Prepared for
Art Gallery of NSW
Date: 20 June 2019

Response to Submissions – Section 4.55(1A) Modification to SSD 6471

Art Gallery of NSW Expansion Project – Sydney Modern

drawn Architectus project no 140419					drawing no. DA_2052
				Do not scale drawings.					Revision A

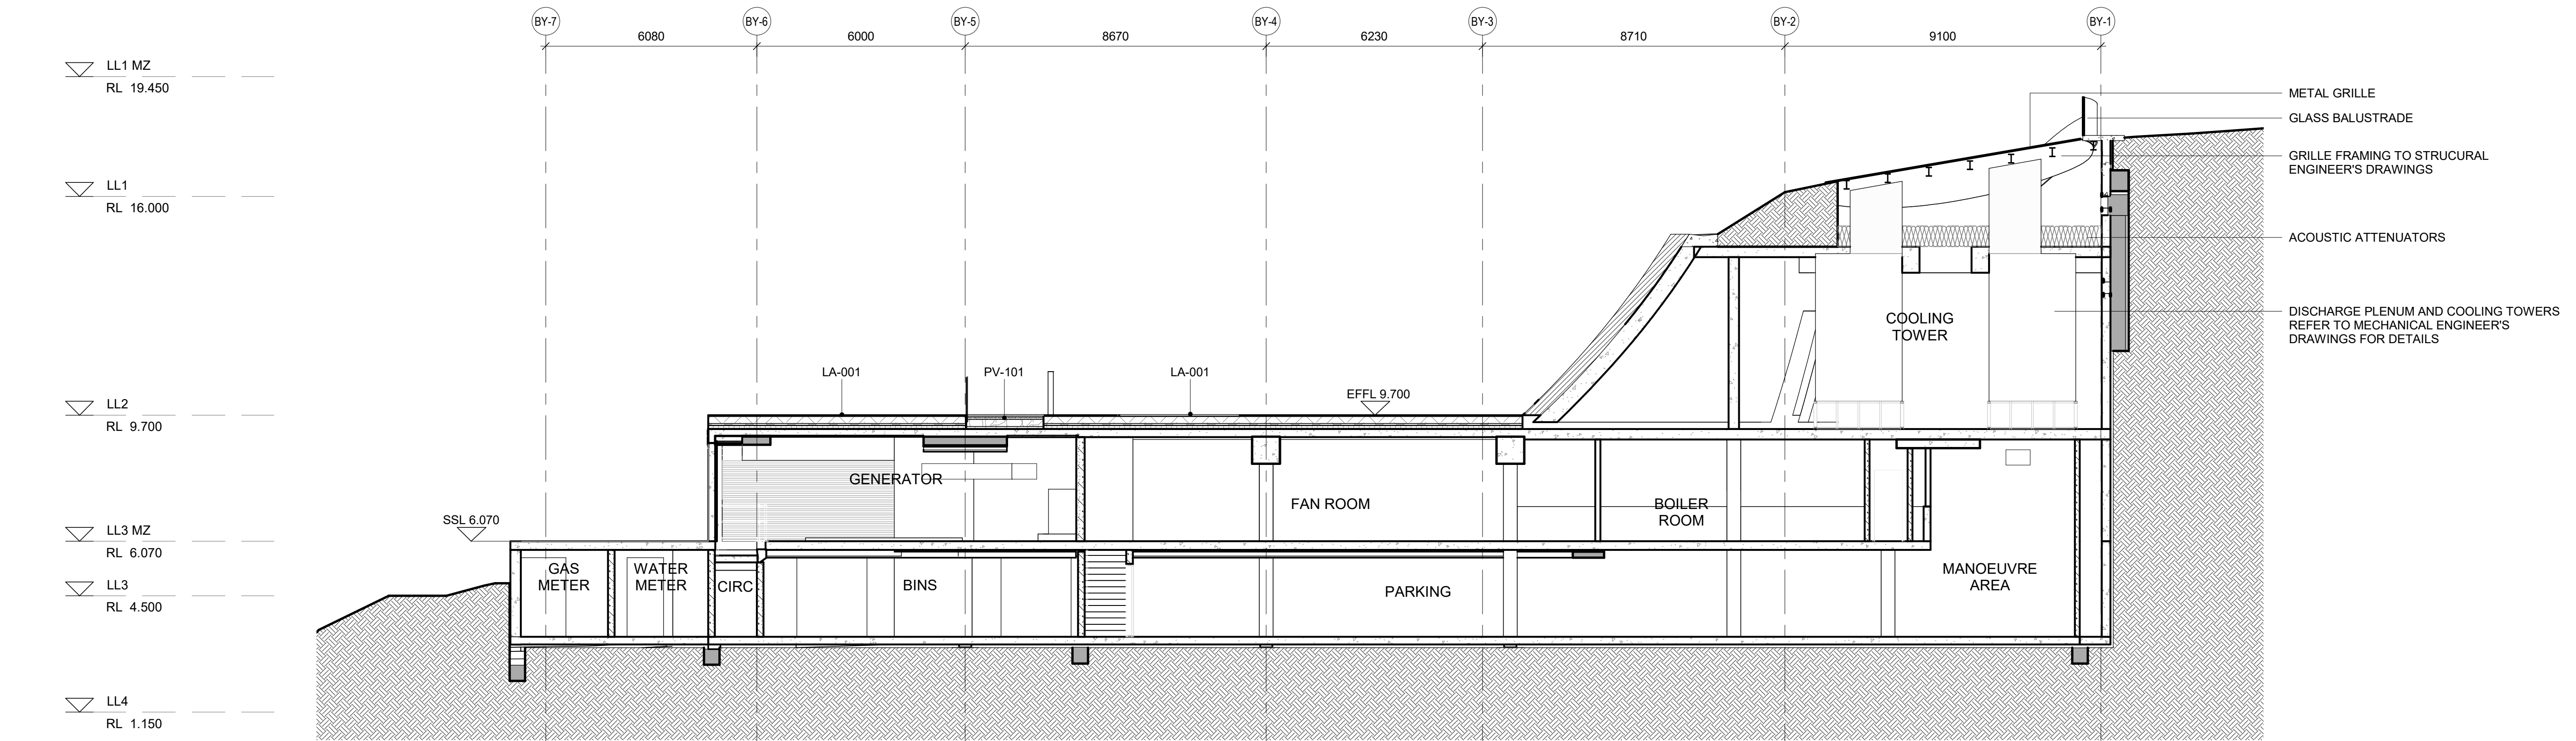
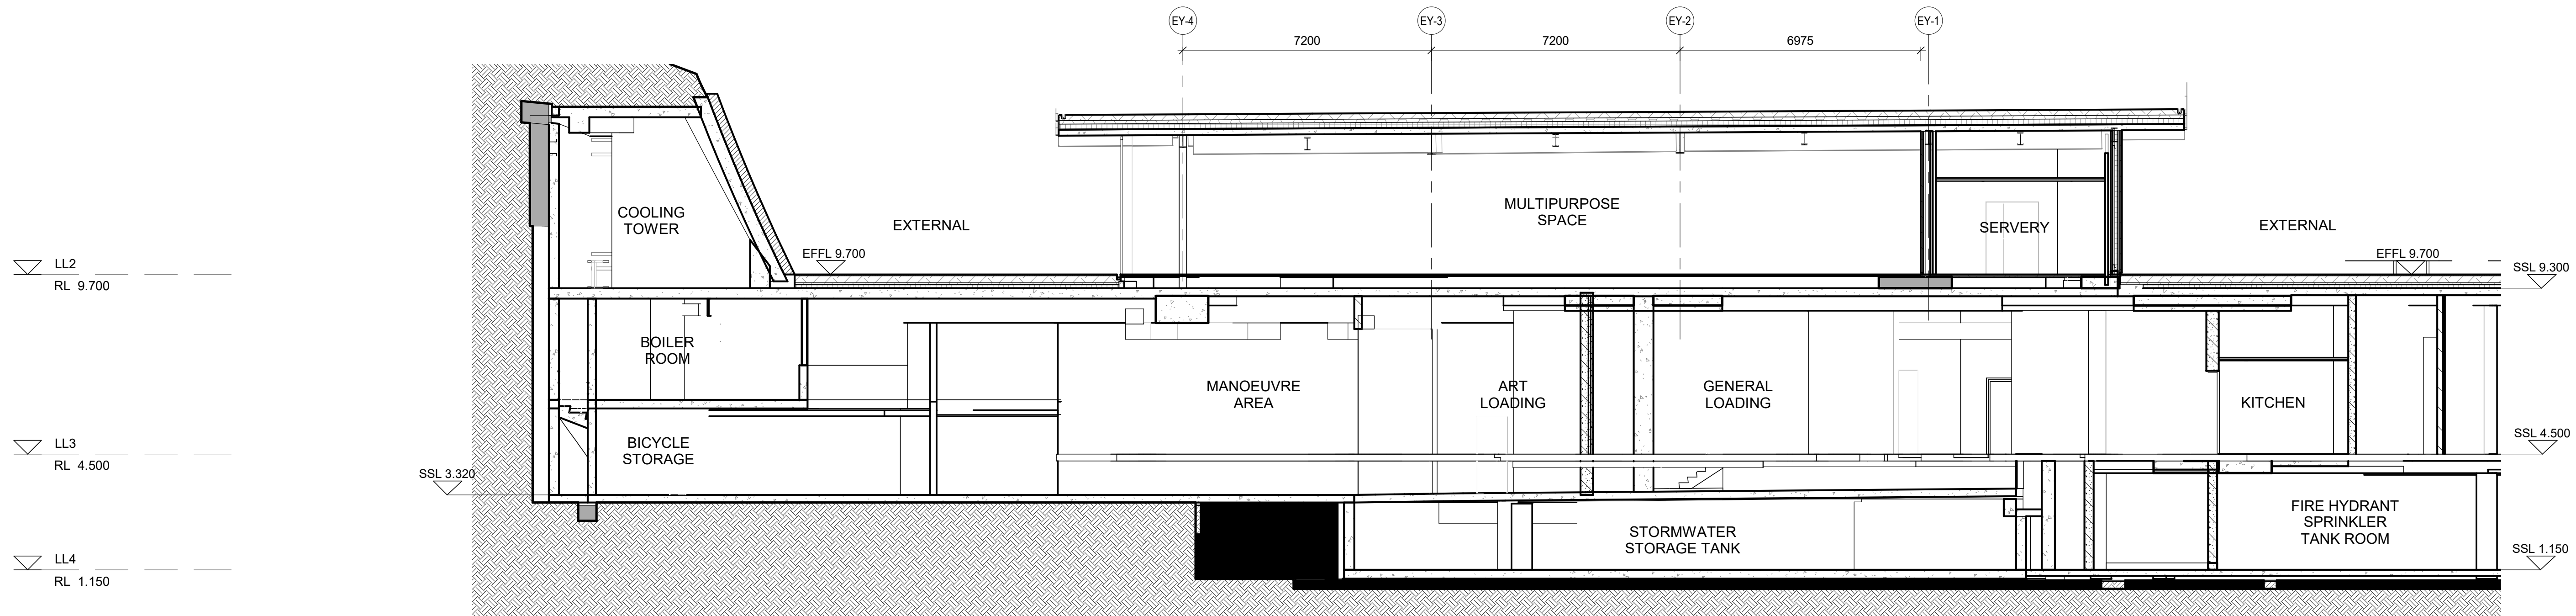
Council and the Heritage Council query the detail of the design and how the air inlet/outlet grille and cooling towers sit within the landscape and interface with the Domain.

Since submission of the Modification, detailed architectural and landscape plans and sections have been prepared for the proposal by SANAA/Architectus and McGregor Coxall respectively, to show how the cooling towers will sit within the building and how the air inlet/outlet grille will sit within the landscape. Refer to these at **Appendices B** and **E** respectively.

- DA_1003.5 [B] - General Floor Plan – Lower Level 3 Mezzanine – (note: this is a plan in the Modification set now amended to show location of new sections);
- DA_2051 [A] - Section 1 & Section 2; and
- DA_2052 [A] - Section 3 & Section 4.

**Sheet Title**  
**Cooling Tower Corner**  
**Sheet No.**  
LD\_DA\_00-17

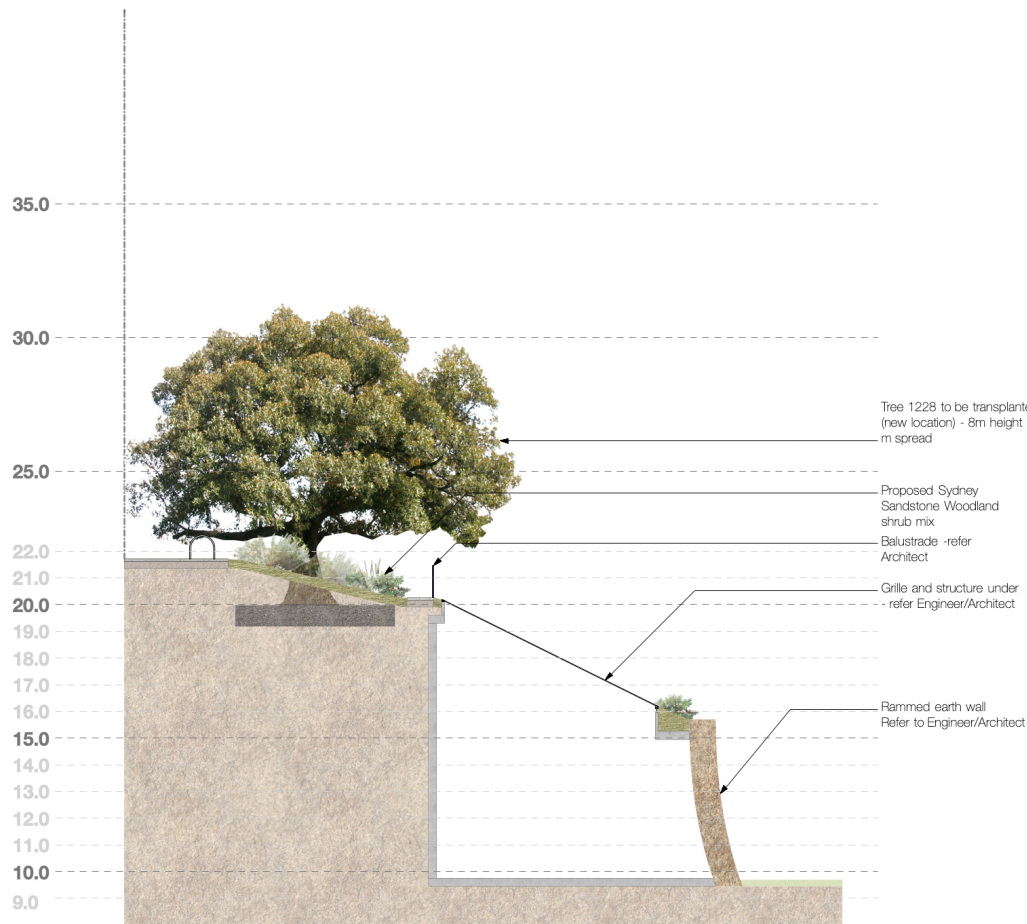
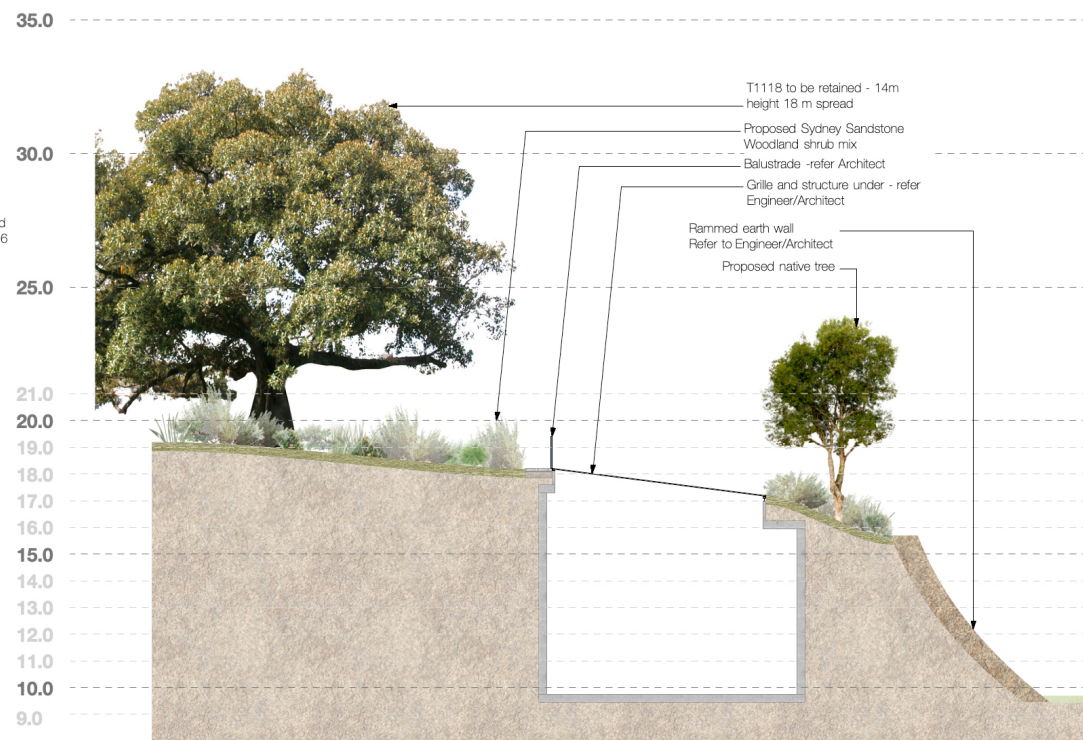
The City of Sydney Council requested additional information on the impact of the cooling tower exhaust on nearby existing and proposed trees. Council also requested design details of the air inlet/outlet grille in architectural and landscape documentation, and clarification of its impact on visual amenity, and comfort of the public domain.

- There is a distance of 12.7 metres from the existing tree T1118 (edge of trunk) to the edge of the air inlet/outlet grille. The air inlet/outlet grille is located outside of the Tree Protection Zone (TPZ) and canopy of T1118;
- The distance from the relocated/transplanted T1228 (edge of trunk) to the edge of the air inlet/outlet grille is 4.5 metres;
- Air velocity from the air inlet/outlet grille (around 2 metres / second);
- Air temperature difference (around 5-6 degrees Celsius adjacent the air inlet/outlet grille and this warm air will dissipate and lessen as it moves outwards); and
- Trees are Australian natives and generally heat tolerant.

Detailed landscape plans have also been prepared by McGregor Coxall landscape architects with a plan and sections through the air inlet/outlet grille. Refer to the sections at **Figure 4** and **Figure 5** below and the full documentation at **Appendix E**.

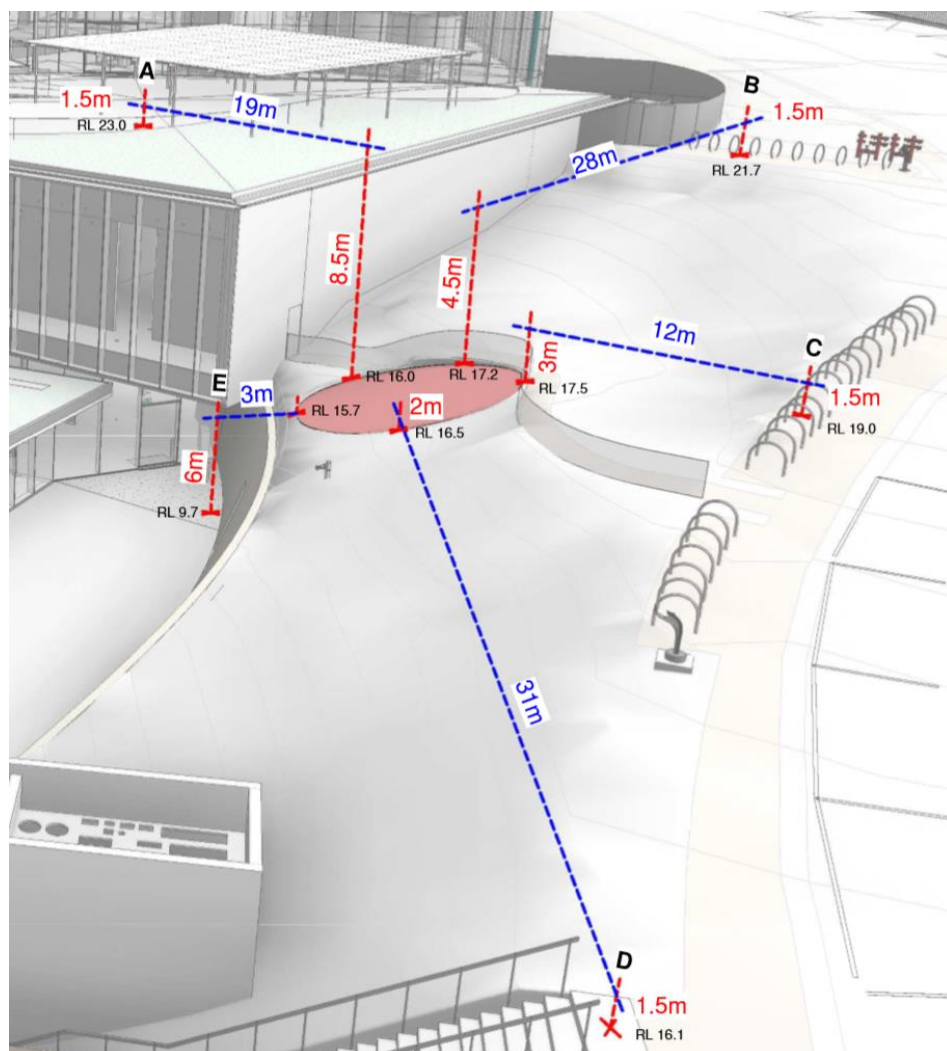
Council in their earlier email submission, query the impact of heat exhaust on pedestrian comfort.
